Libbytown Neighborhood Association  
c/o 11 Stevens Ave  
Portland, ME 04102

June 30, 2015

Re.: Future Jewish Community Center  
1342 Congress Street  
Portland, ME

LANDSCAPE PLAN

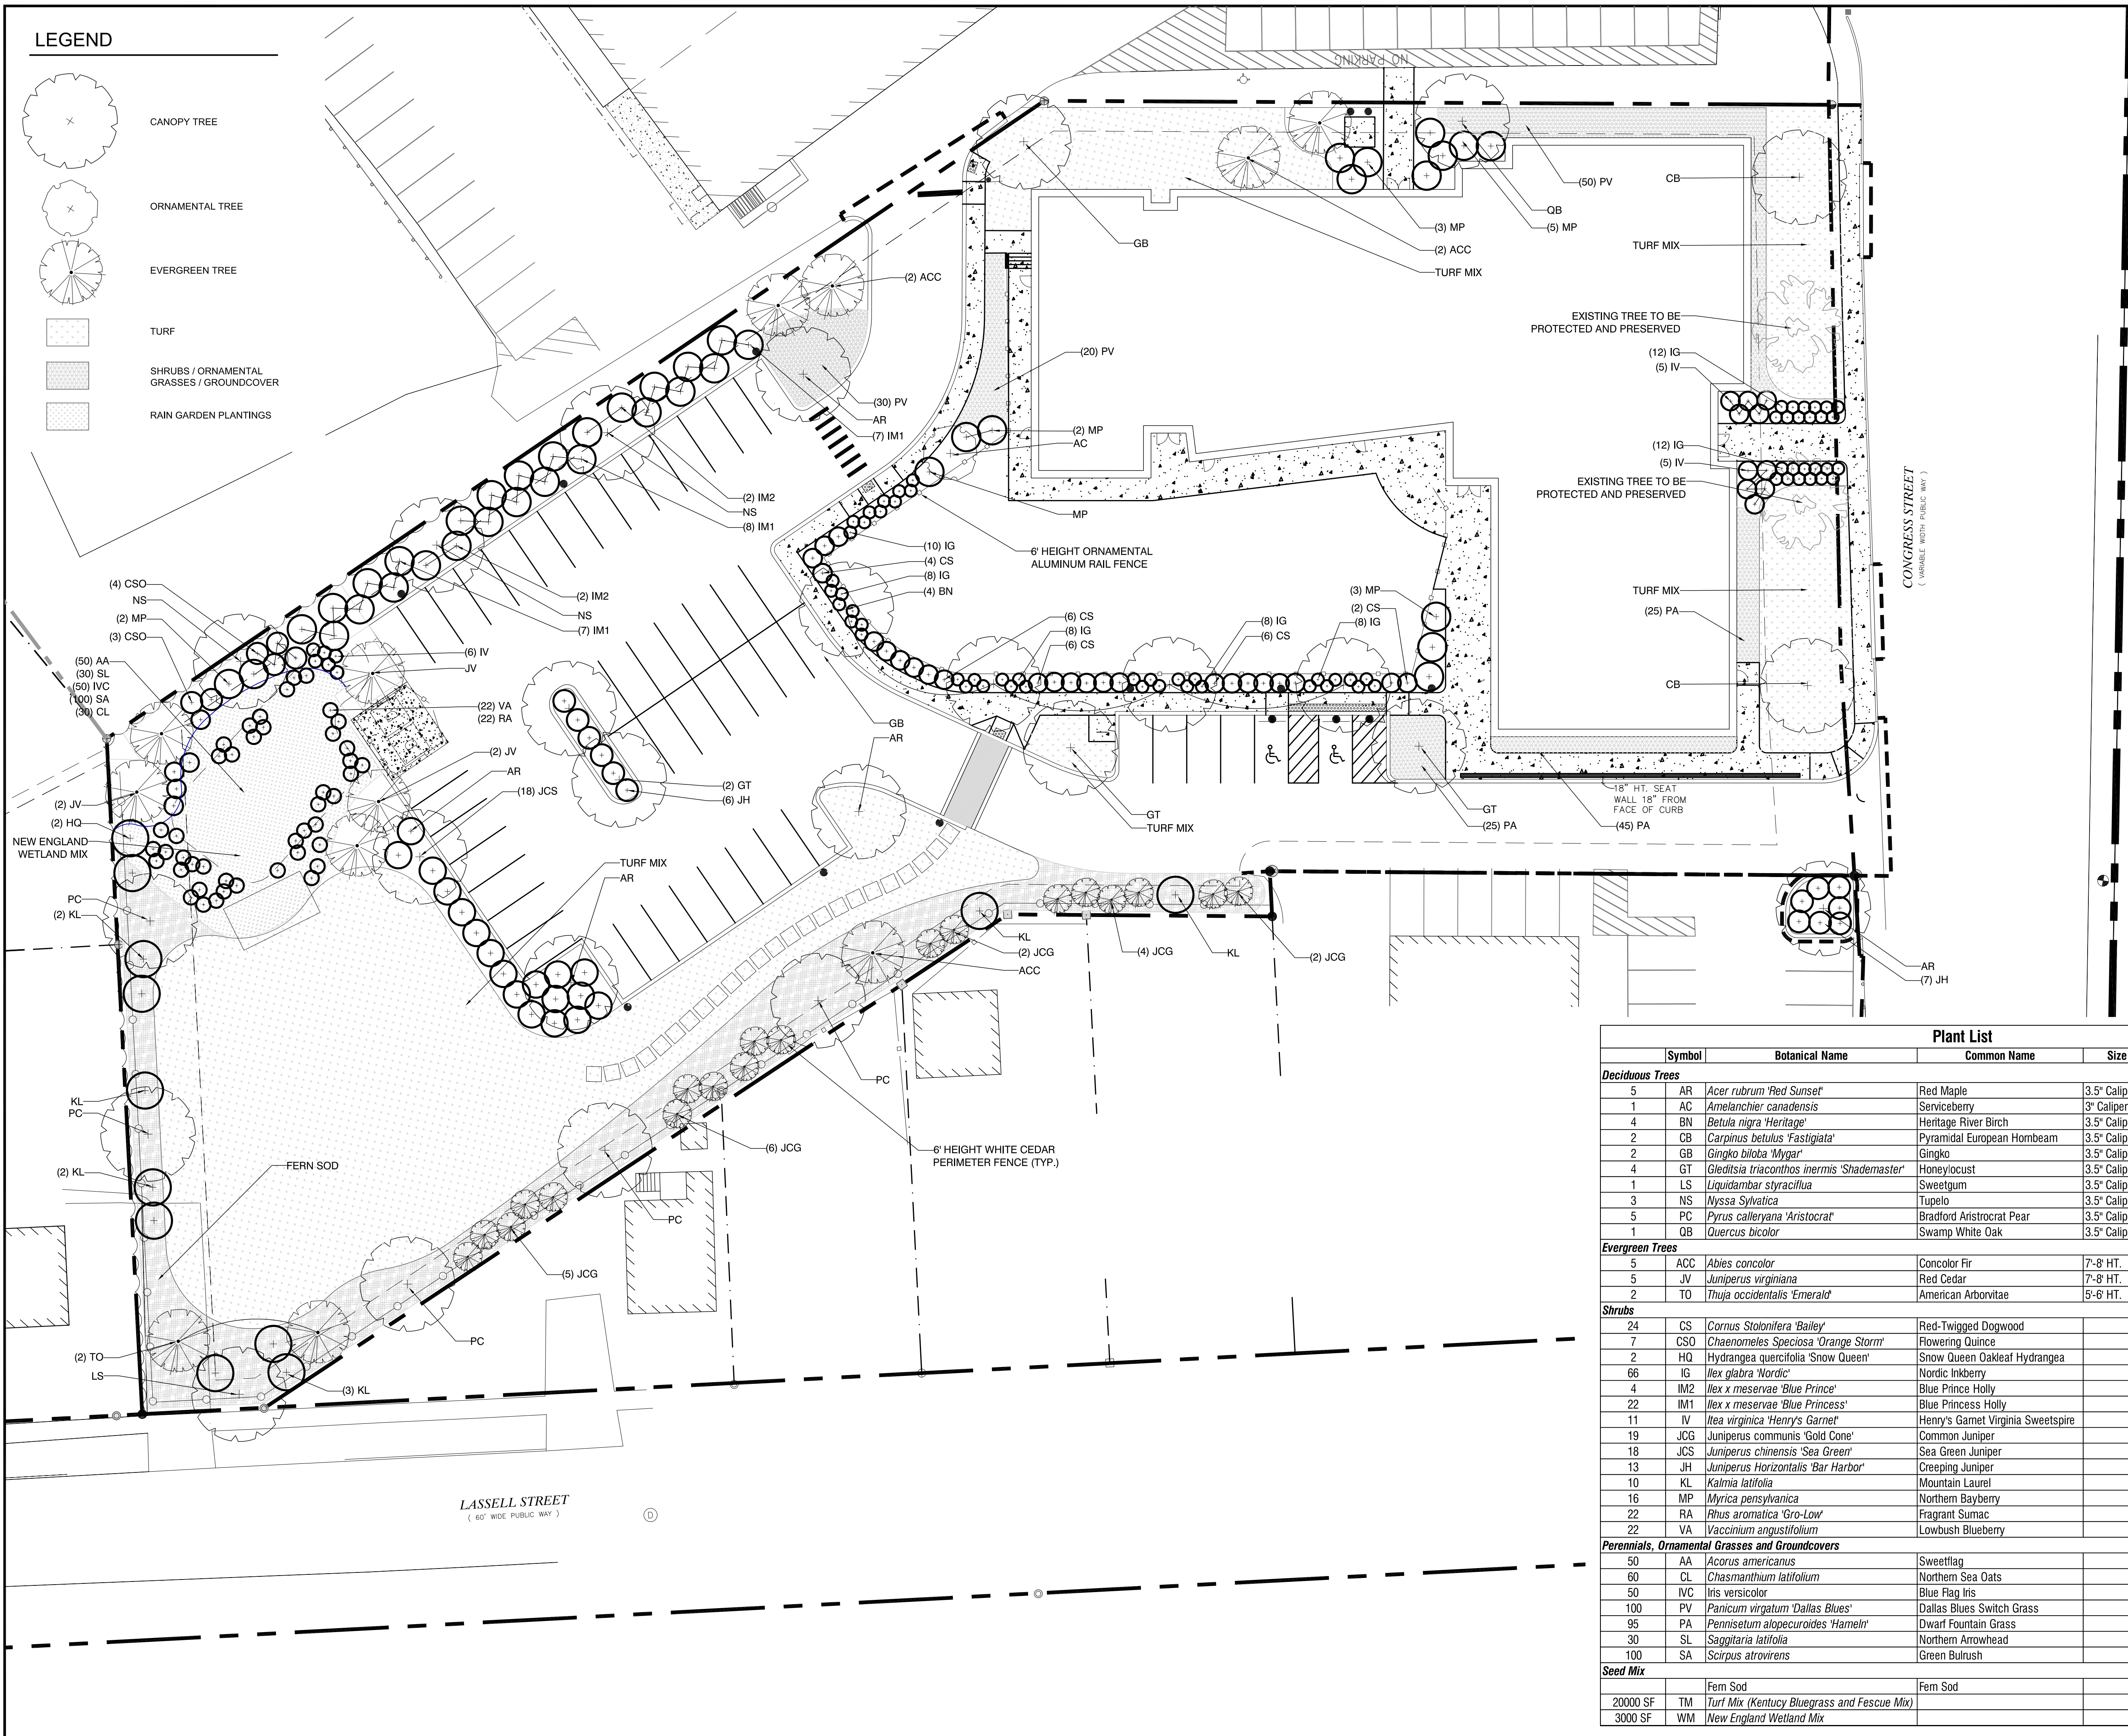
- Parking is not greatly expanded, as there is adequate unused parking next door at Westgate.
- We are especially glad you are keeping the existing trees and adding additional trees, and preserving most of the green space in both the front and the rear of the property. Trees shade pedestrians, and also make the street feel smaller and thus help calm traffic.

The LNA has been working hard to establish a community garden in the area, and are indeed excited to see that you are including some edible plants in your landscape design (lowbush blueberries). We would encourage you to replace other plantings with even more edibles as well. For example, replacing the dogwood tree with an apple tree or cherry tree. Additionally, work nationwide has focused on increasing children's access to vegetable gardening and we would encourage building this into the plan for the daycare facility as well.

A20.2

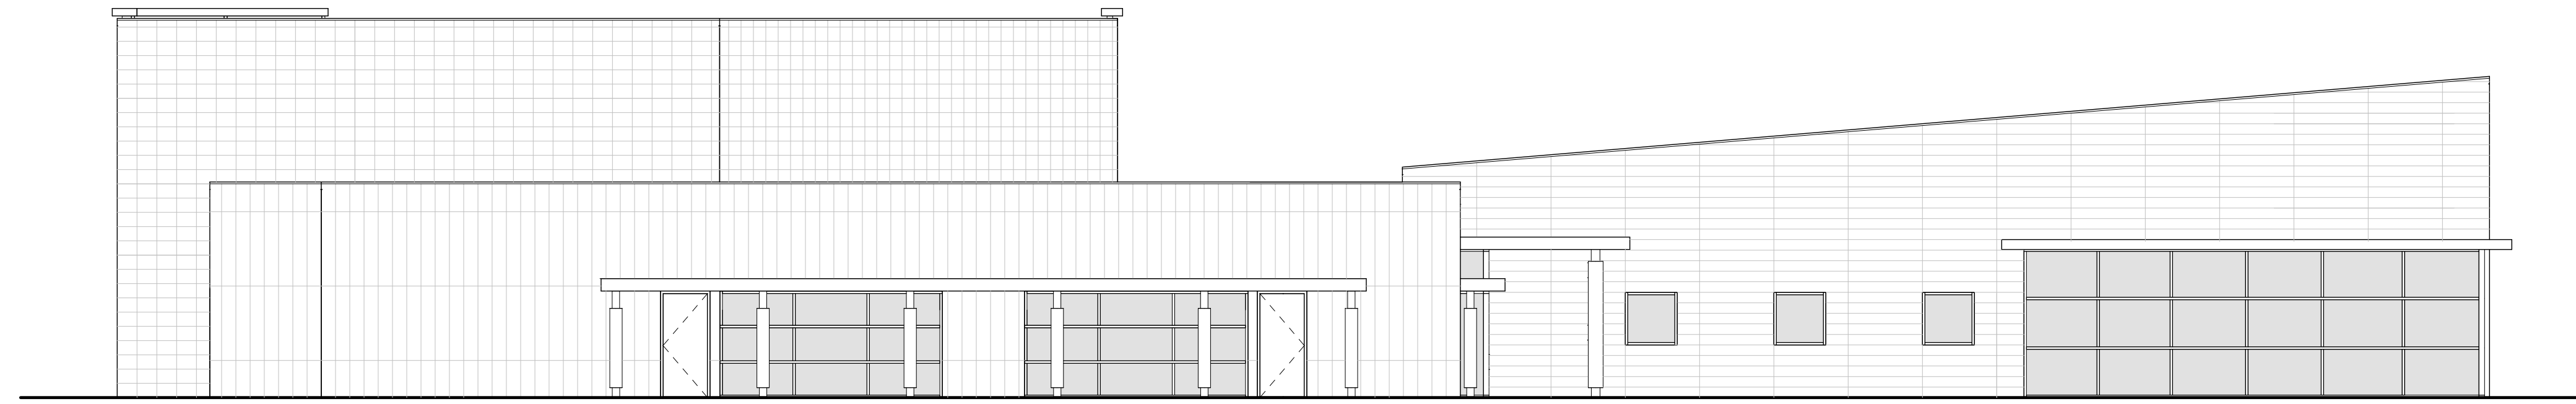
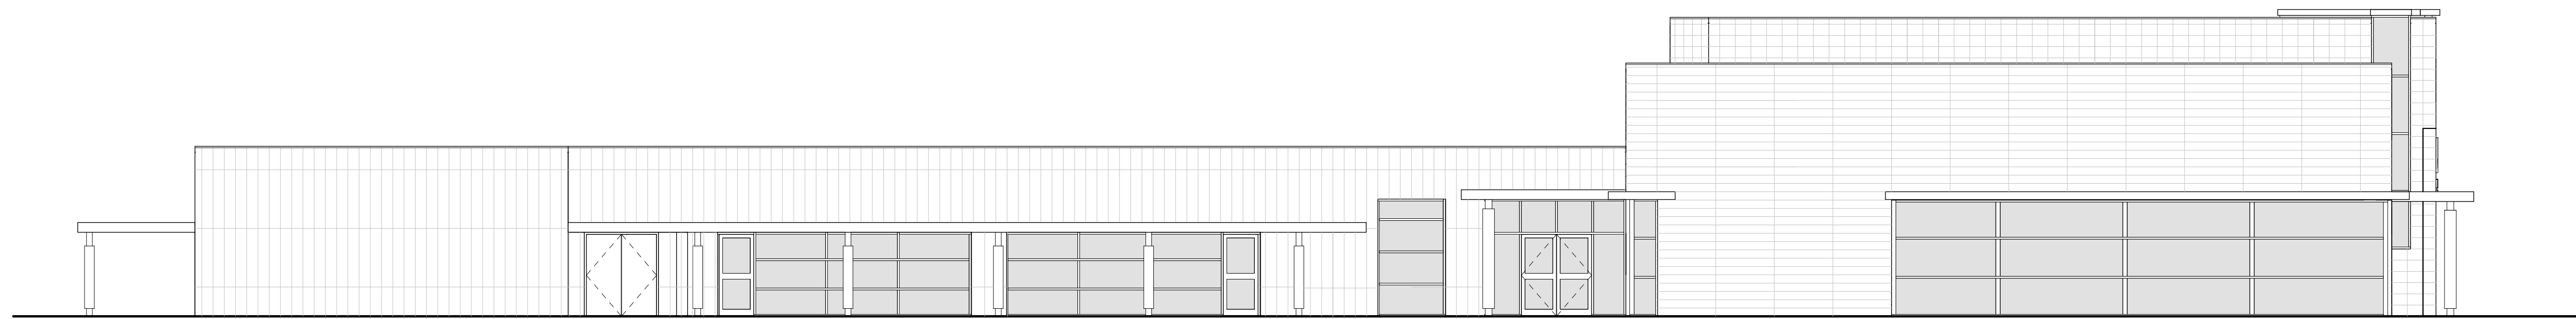
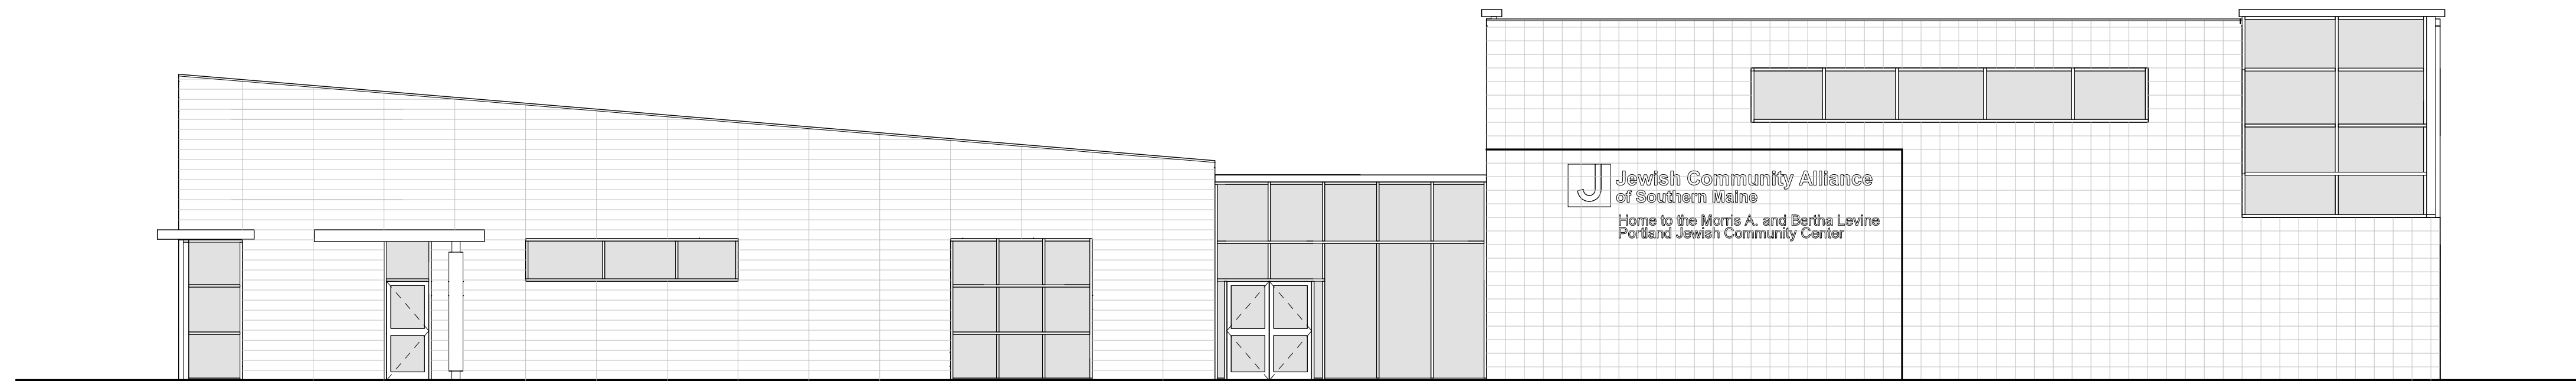
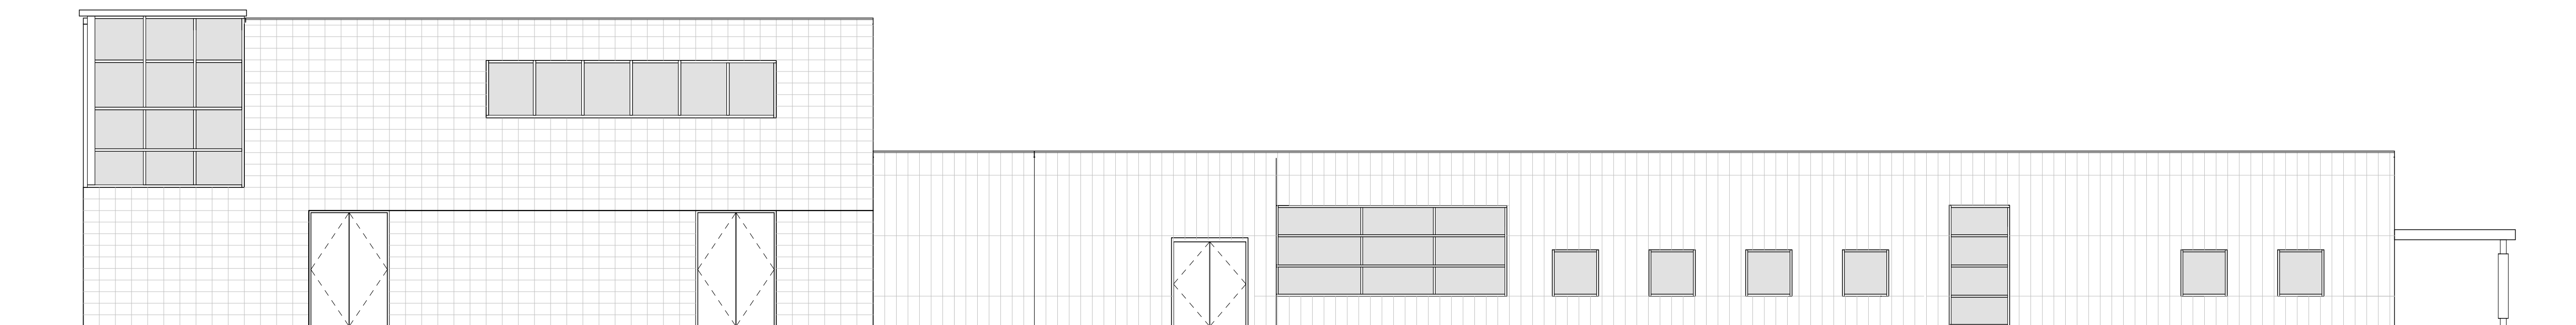
One of the concerns we do have is that the front facade at the gymnasium, as presently drawn, is a large, blank box (Harriman Associates, Drawing A201, undated). We see on the revised exterior elevations dated June 24, 2015 that some additional embellishment has been added, but we hope for additional enhancement as well. We understand these are preliminary drawings and we hope that as the plans develop, some sort of visually-stimulating feature – perhaps a mural, or mosaic, or even large banners – will be integrated to enliven this blank area. We want to keep our streetscape interesting, fun and engaging to those who are walking by at a slower pace than quickly moving autos.
